January
~~December~~ 4, 2017

RE: **Signal Pointe Subdivision**
Release of Financial Guarantee Certification
Engineer's Stamp Date 7-21-2016 (File: C20D0070)

November 3, 2016

RE: **Signal Pointe Subdivision**
Pad Certification – All Pads
Engineer's Stamp Date 7-21-2016 (File: C20D0070)

GRADING & DRAINAGE PLAN

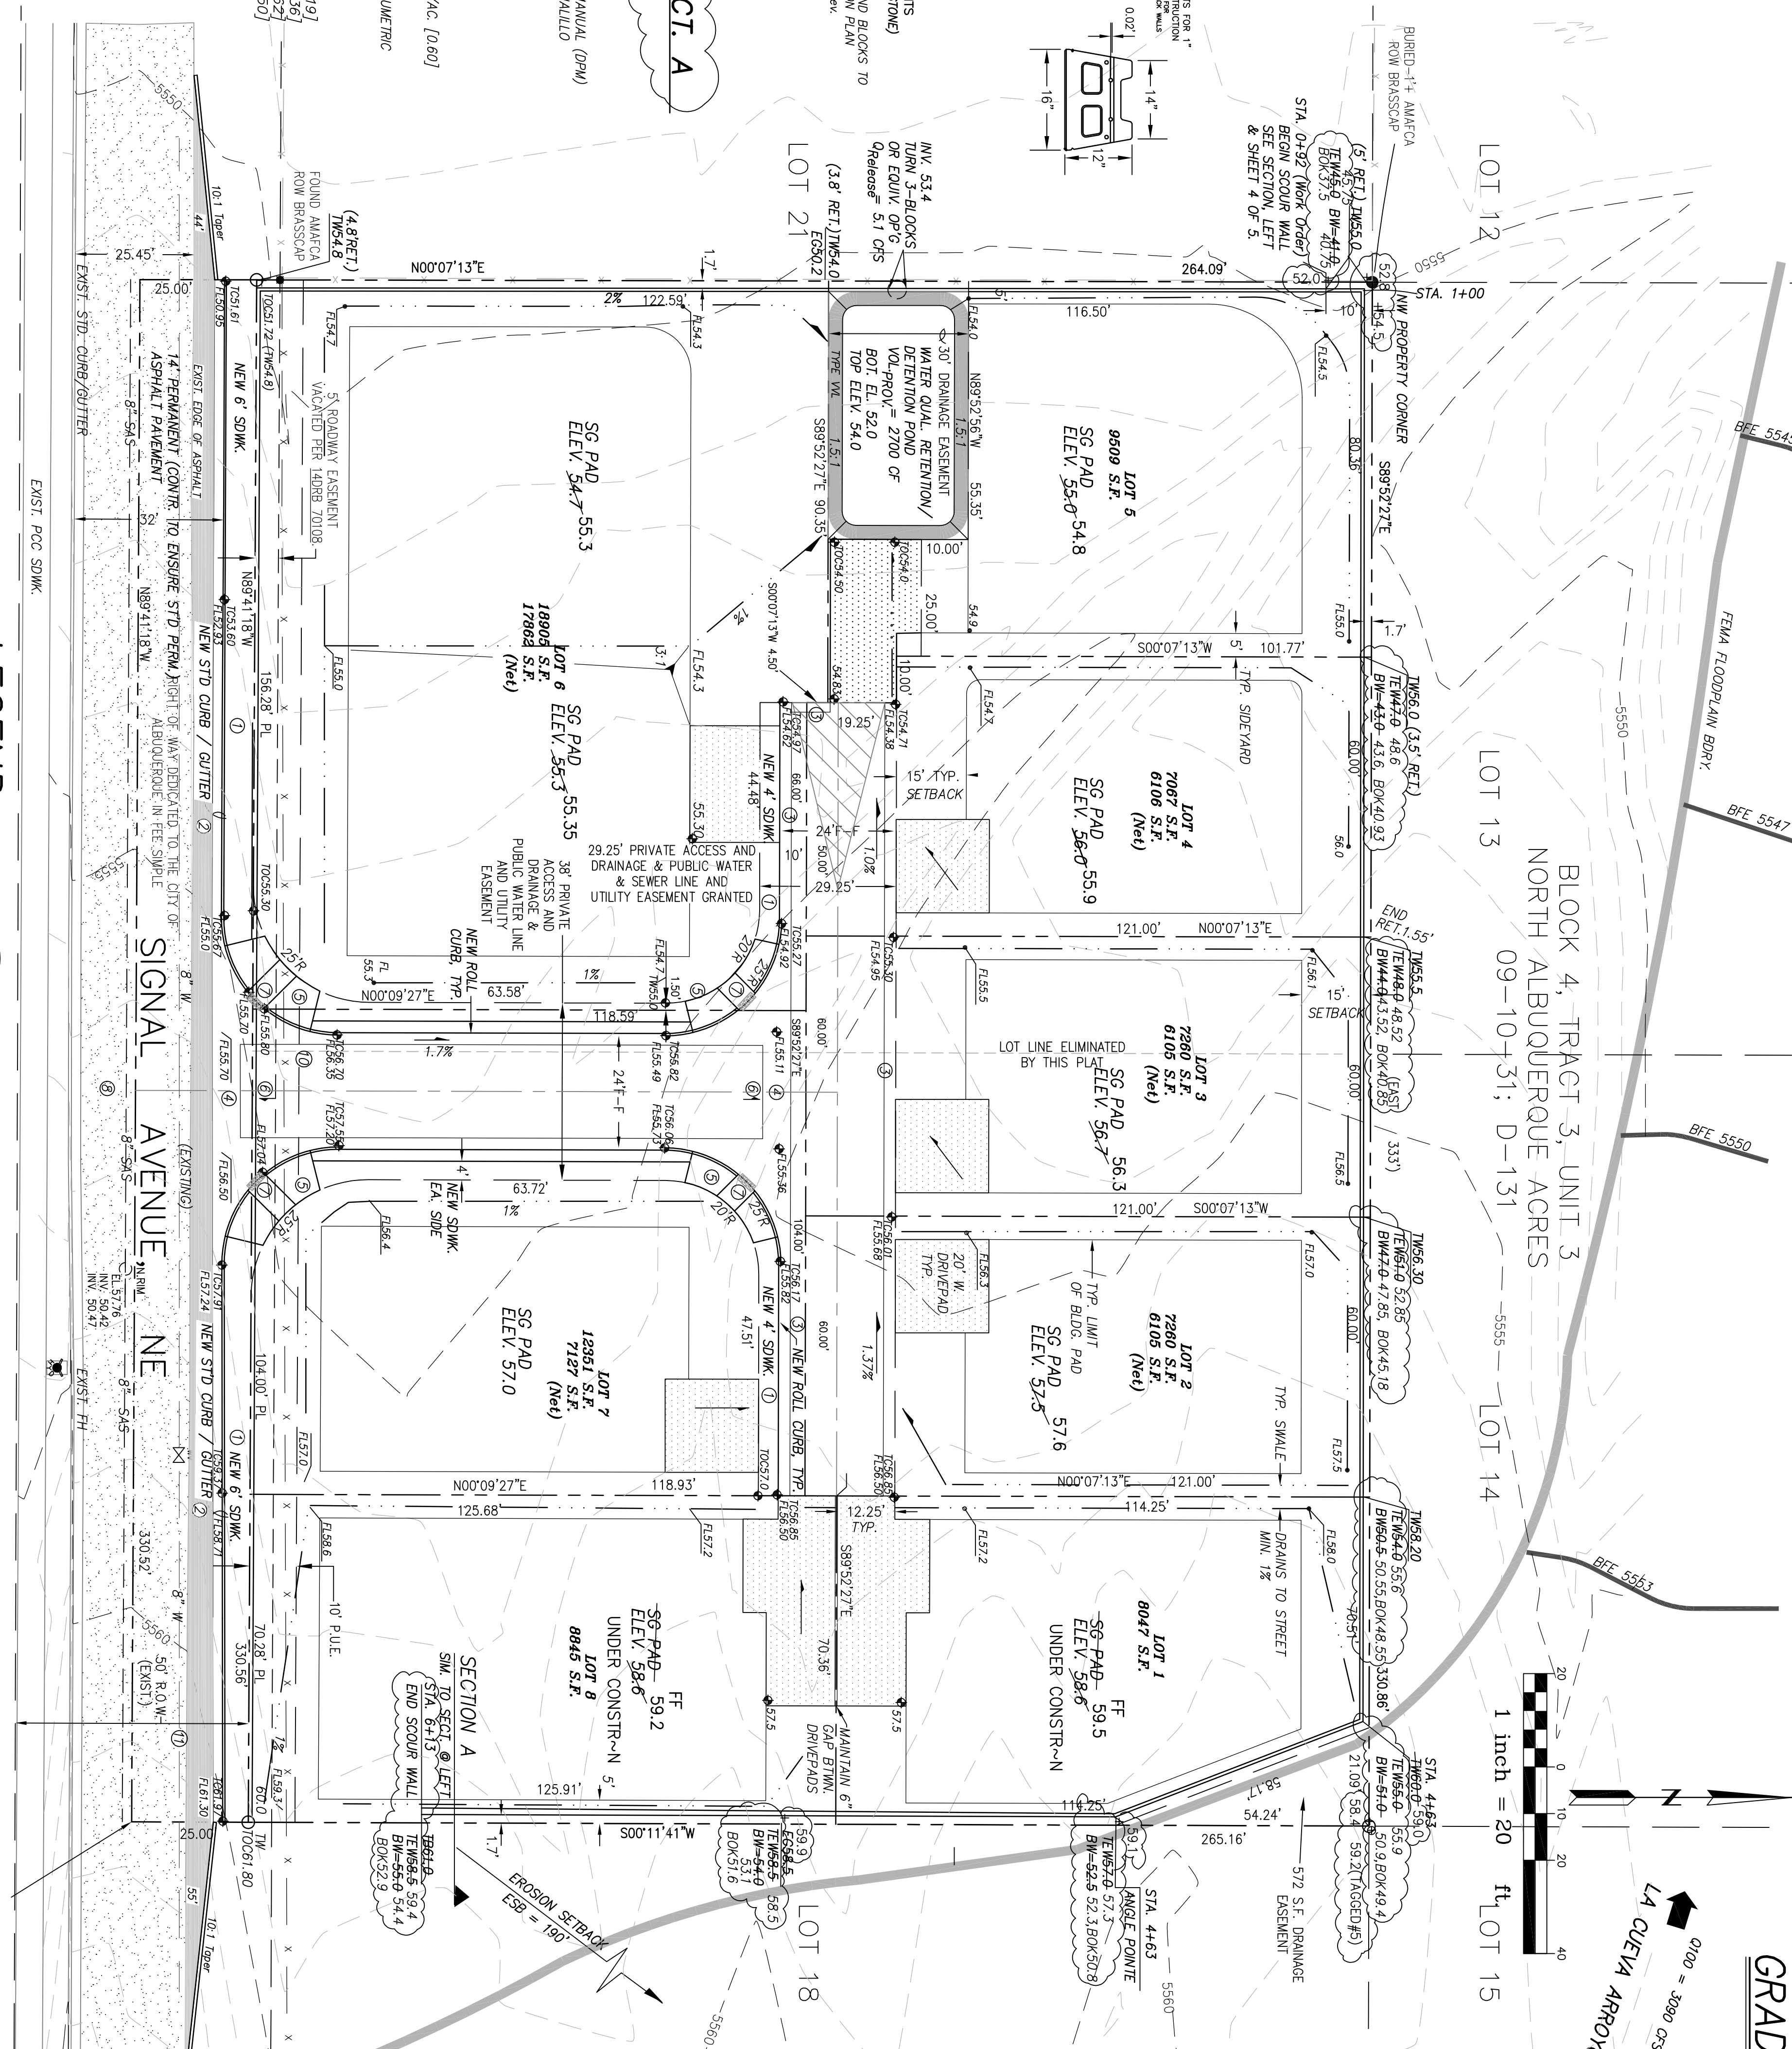
1. The turn blocks were not incorporated into the western wall, as an outlet for the water quality pond. This has the potential to adversely affect the home that is currently under construction on Lot 5 when the subdivision is built out. This will need to be addressed before any further action on this subdivision is approved (final plat, ROFG, future building permits).

Based upon the information provided in your submittal received 9-20-2016 (electronic copy received 7-21-2016), the above referenced Grading and Drainage Plan is approved for Release of Financial Guarantee. The conditions described in the Pad Certification are satisfied (turn blocks).
